A66 Trans-Pennine Project Scheme 0102 – M6 Junction 40 to Kemplay Bank

This is written response to Document 7.6 - Applicants Response to the Written Representations - on behalf of Penrith Properties Limited, BVI registered company 249033, (PPL) in respect of the proposed acquisition of land identified in Developer's Application Document 5.13 as Plot 0102-01-20 at Ghyll Mount, Gillian Way Penrith.

Drawing Number	Project	Originator	Volume
HE565627	- AMY	- HAC	-
S0102	- DR	- YL	- 000002
Location	Type	Role	Number

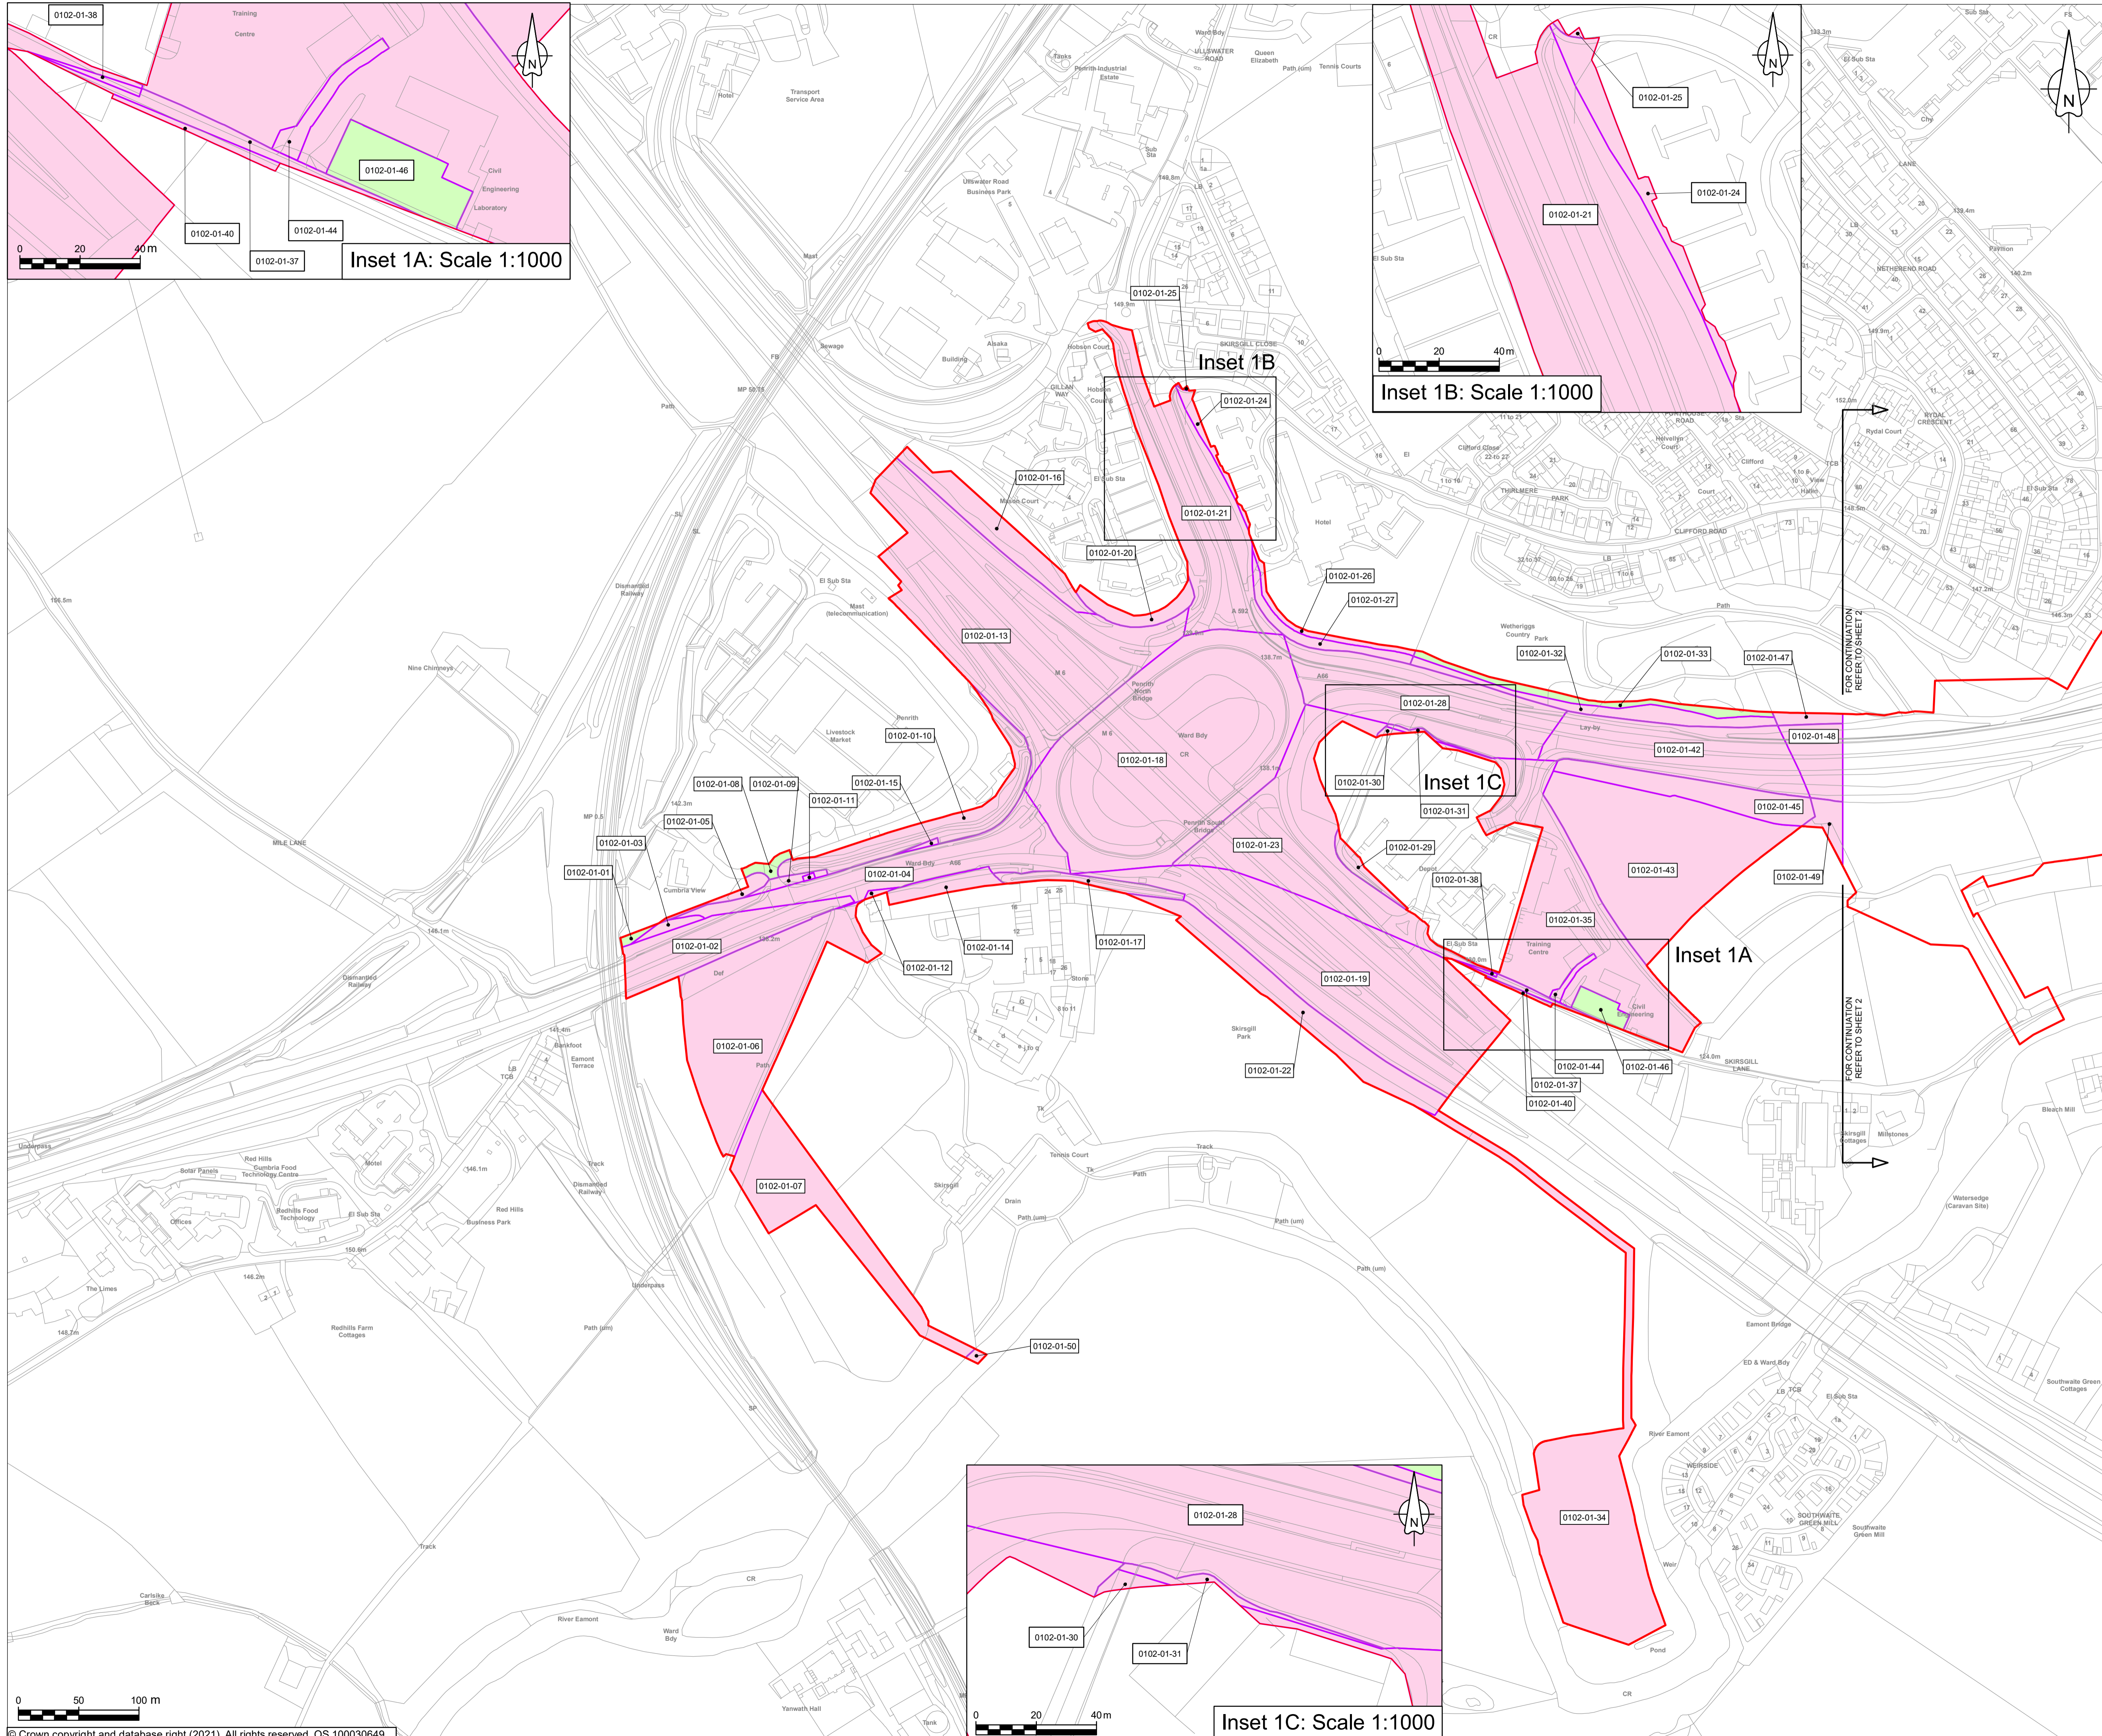
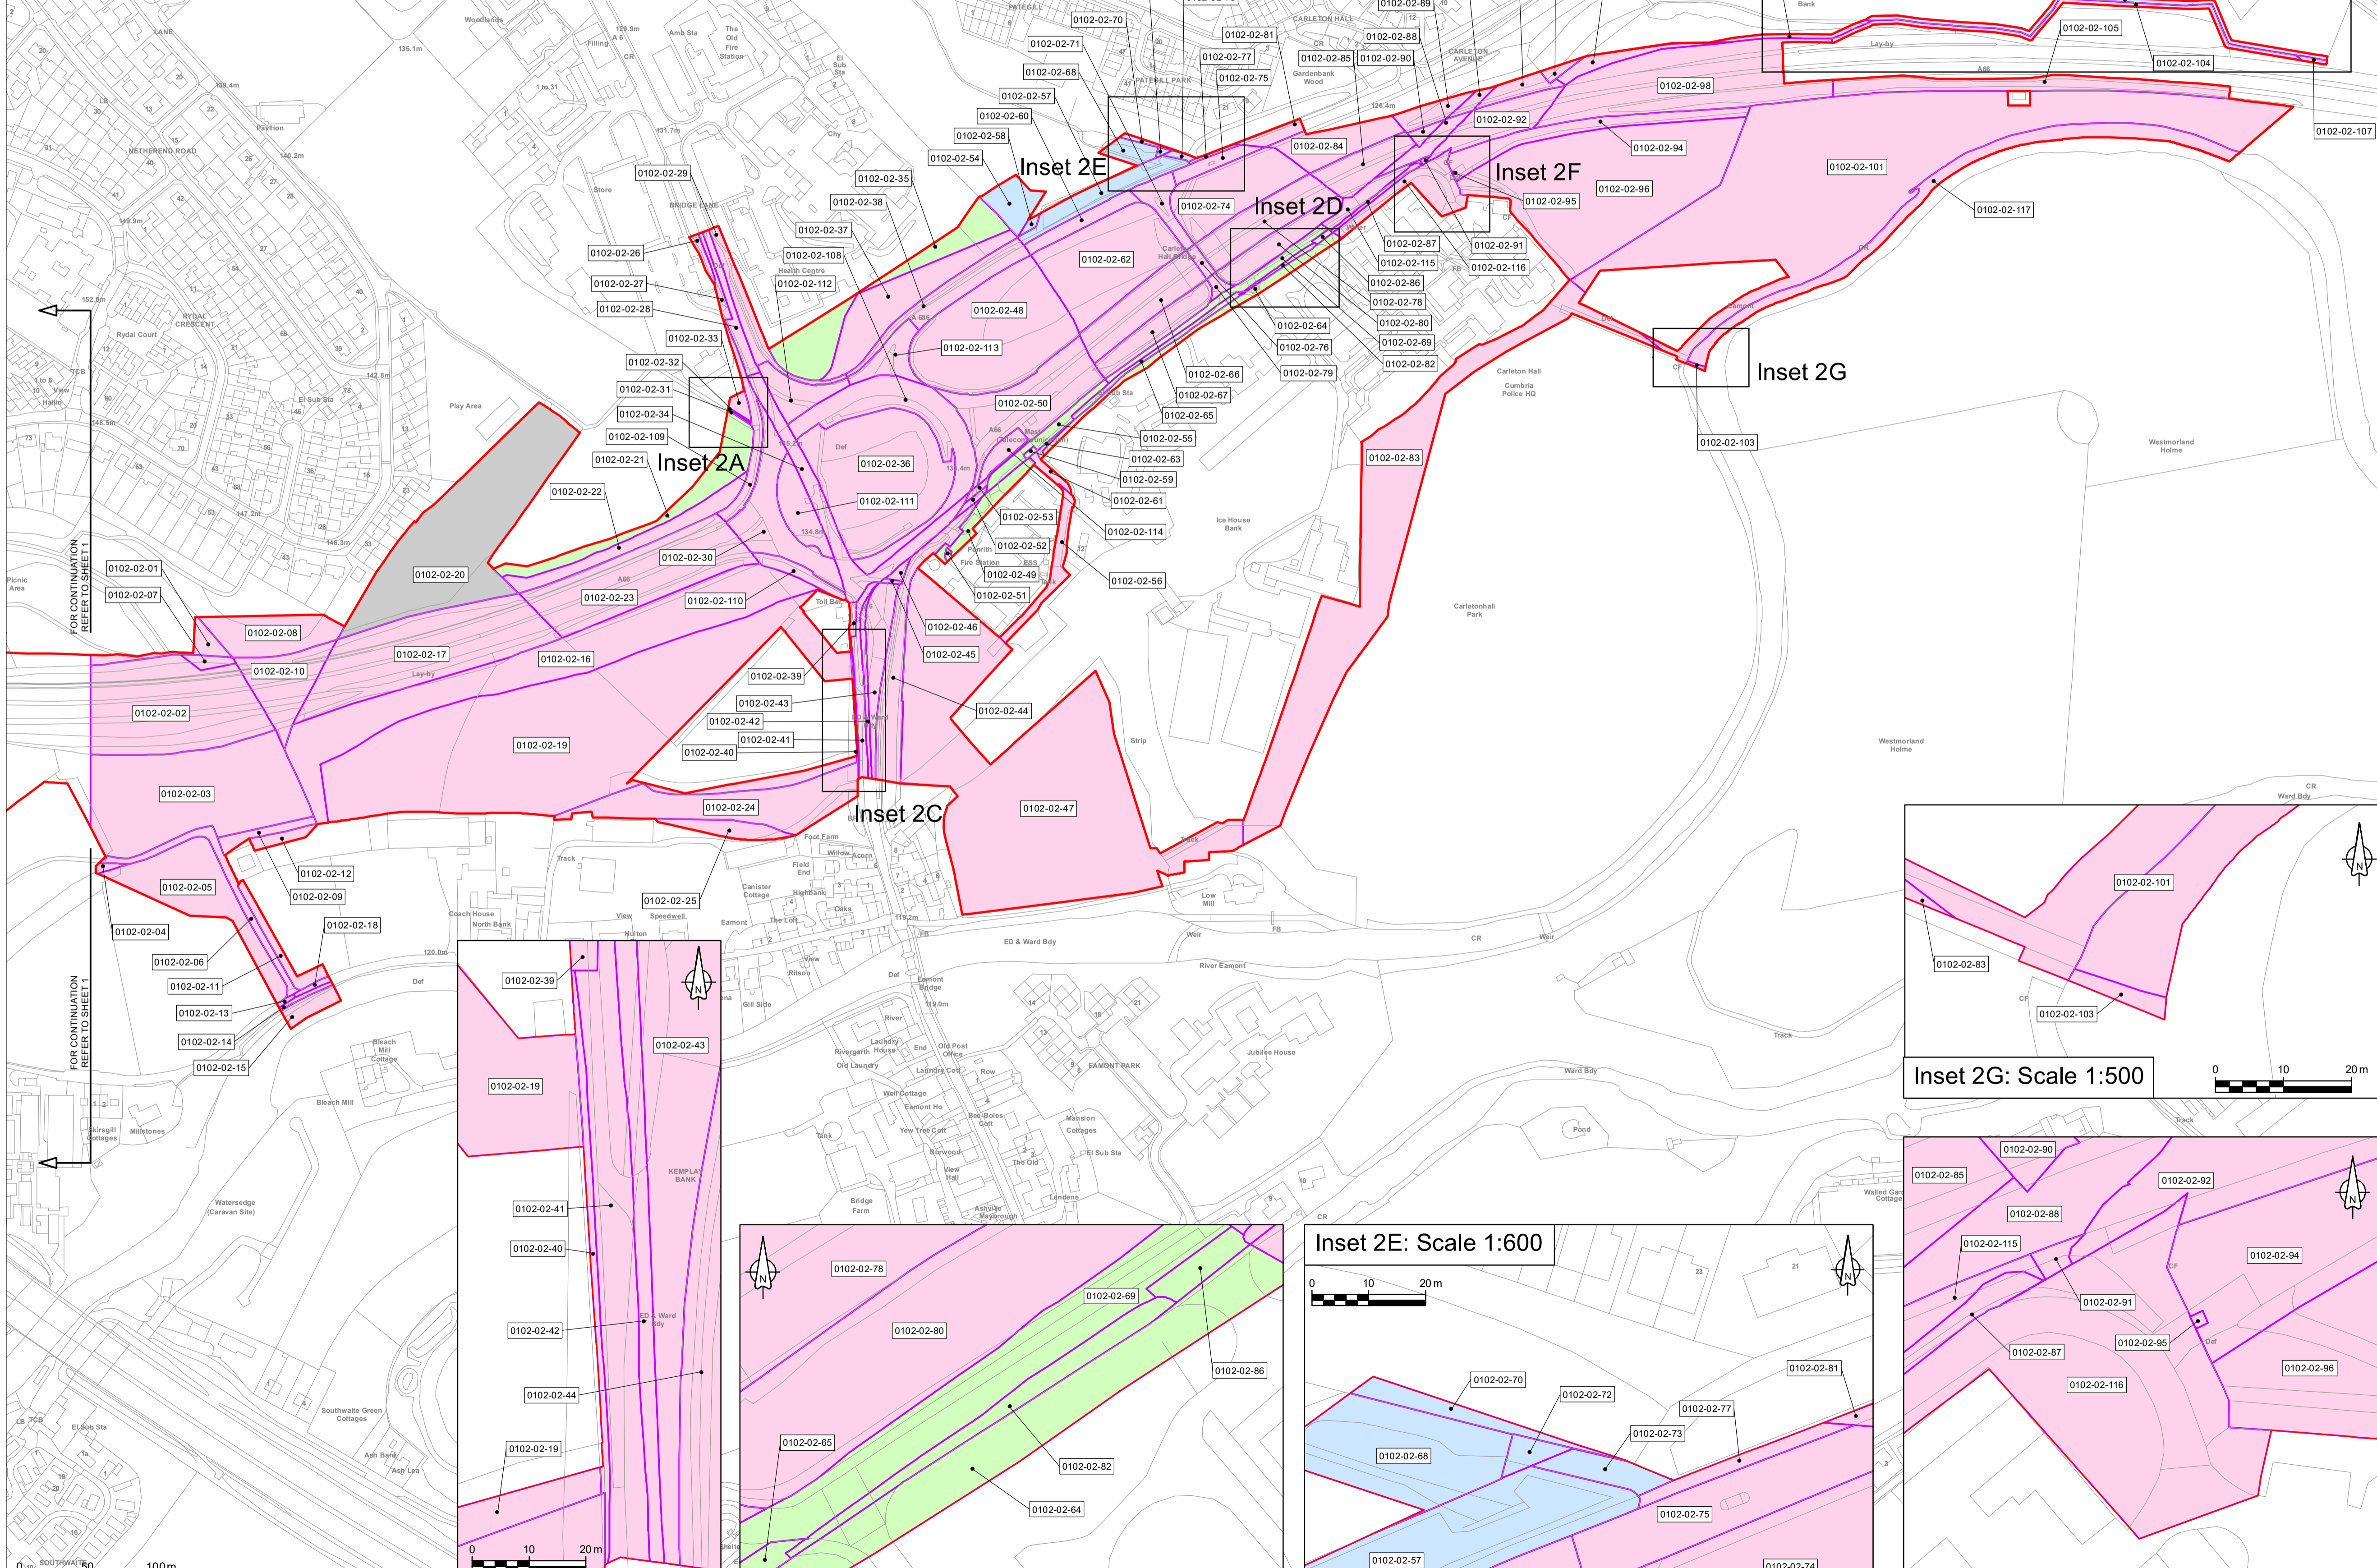
The Applicant confirms that land identified as pink – permanent land taken - may not be taken but may be subject to a temporary possession or possession by agreement.

PPL requests that the Applicant clarify what and why land is required given the lack of supporting evidence demonstrating it is necessary for the scheme and engages with PPL to determine a reasonable approach if the land is so required.

For the sake of clarity PPL do not believe the land identifies as plot 0102-10-20 is required to enable the scheme to be delivered for the reasons stated however in so far as it is strictly necessary for the scheme PPL would enable access by agreement to the land to carry out identified works on the strict proviso that it is reinstated with an appropriate boundary treatment in its existing location.
